10-lot plot BOCC Public Hearing

LP-18-00002 Suncadia Ph 3 Div 14

Public Comment

TRACT LEGEND
 S SERVICE
 AC ACCESS TRACT
 OS OPEN SPACE TRACT

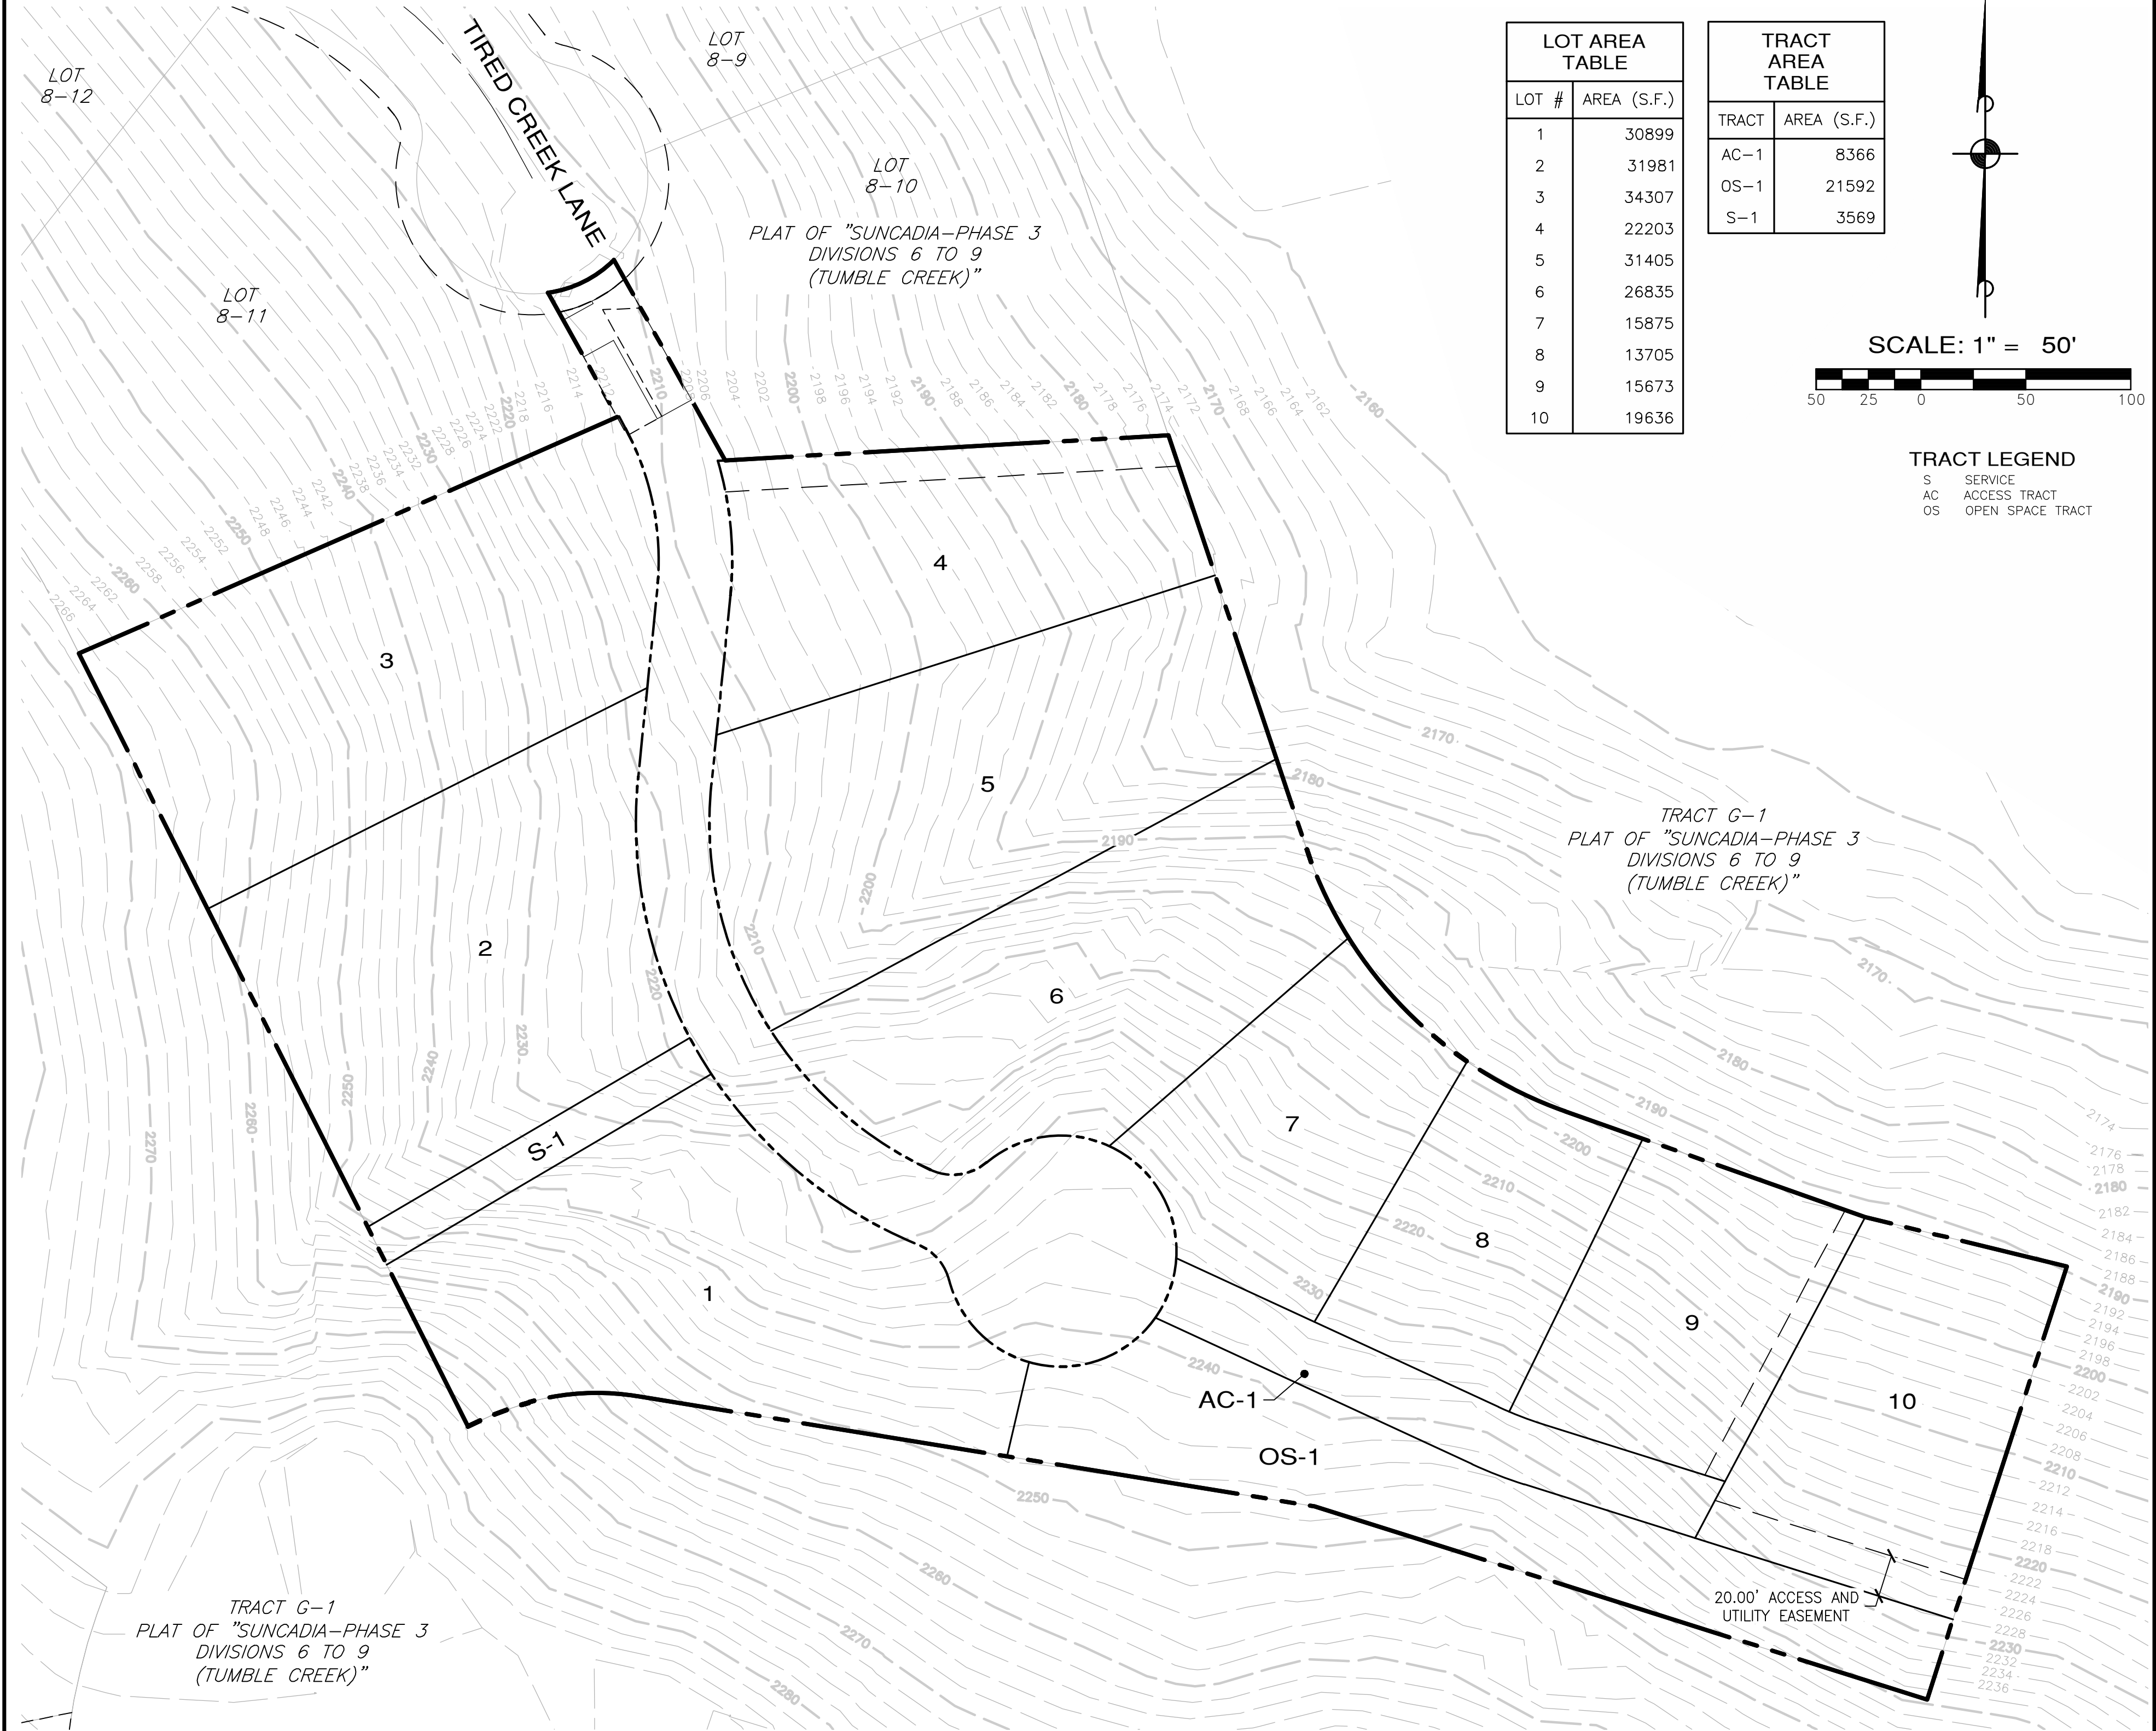
- requesting 30' height on residences

- describes property & handouts -
- lot 10 is unnecessary and removes views
- only allow residents @ 30' & only allow 9 lots, most issues go away.

- significant concerns on Environmental impact
- legal team does not agree w/ consistency finding mainly bc of lot 10
- deny & reconfigure for 9 lots w/ new proposal.
- restrict height to same as existing cabins

- concern is w/ 10th lot because not inline w/ what we purchased
- concerned w/ seismic issues & potential land slide risk, should require geotechnical report
- plan to clear cut 6 acres, concerning
